KITTITAS COUNTY

MEMORANDUM

TO: Kari Braniff, CDS
FROM: Christina Wollman, Planner II *CW*
DATE: September 11, 2008
SUBJECT: Request for More Information
Star View Short Plat SP-08-39

STAR VIEW SHORT PLAT
KITTITAS COUNTY SHORT PLAT NO. 08-XX
PORTION OF THE SW 1/4, SEC. 09, T.20N., R.15E., W.M.
KITTITAS COUNTY, WASHINGTON

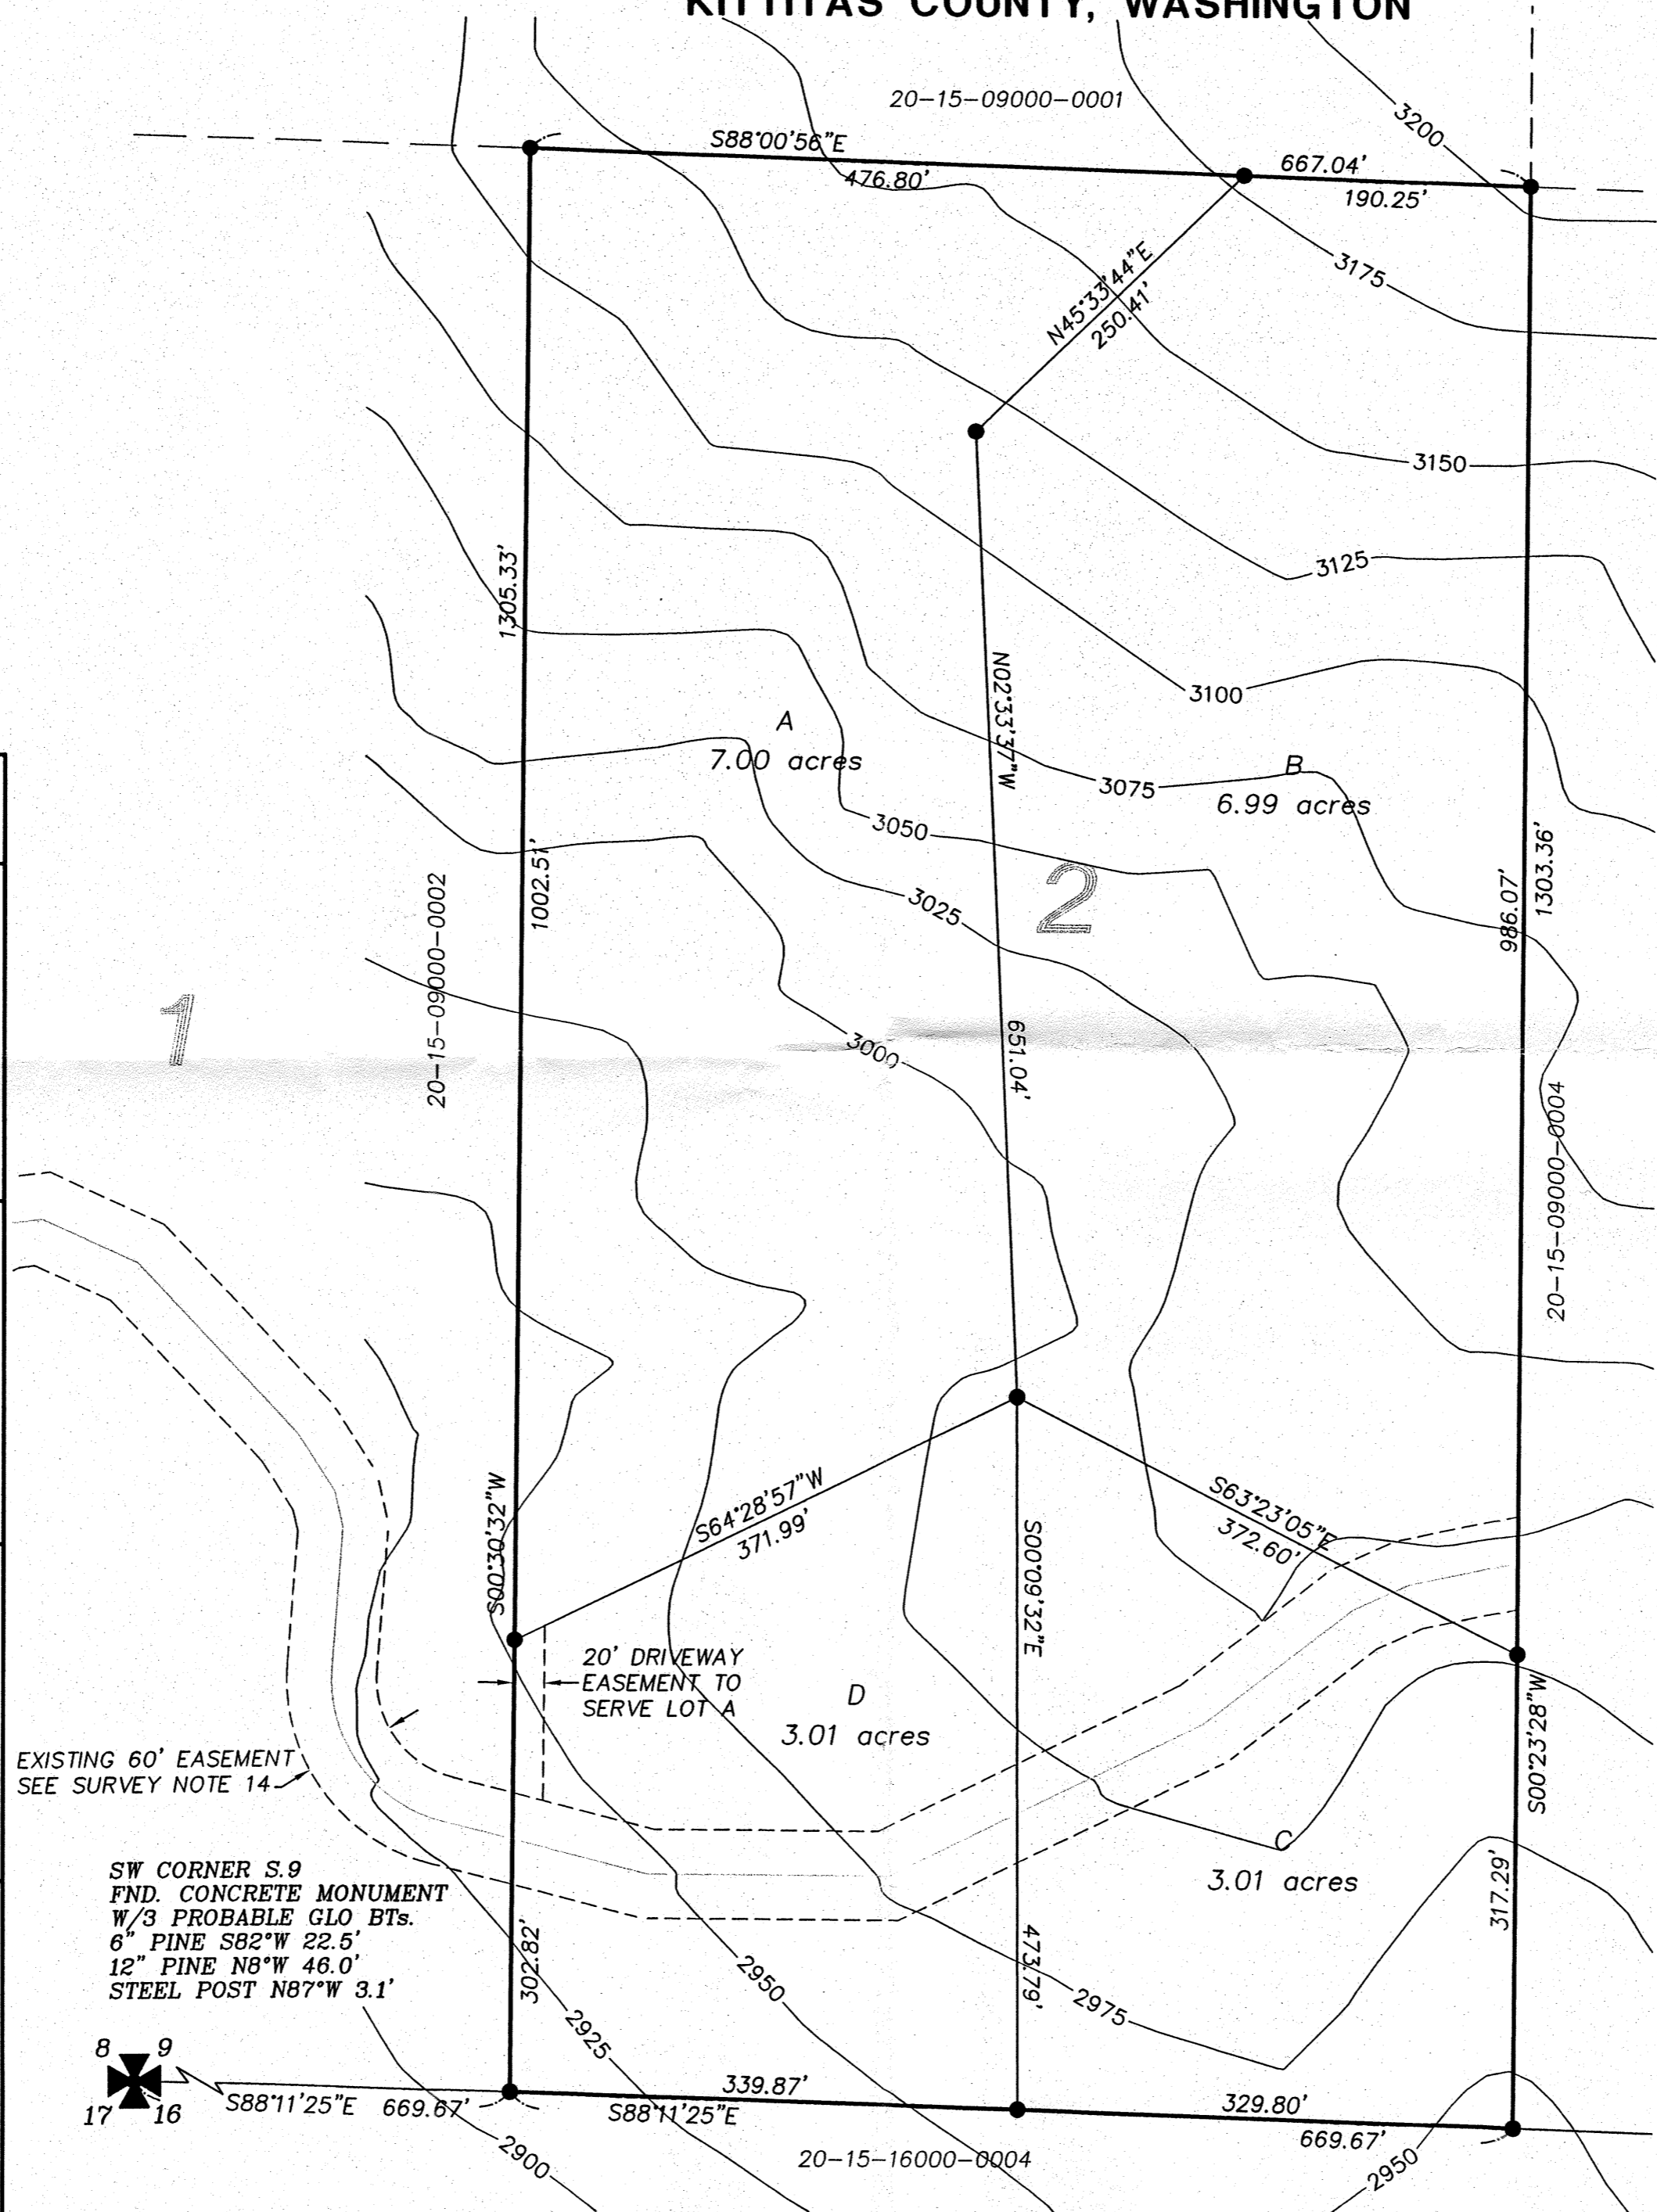
Kittitas County Road Standards require private roads to be no more than 12% grade. R&R Heights Drive appears to exceed the maximum grade requirement. Please provide documentation that R&R Heights Drive does not exceed 12% grade.
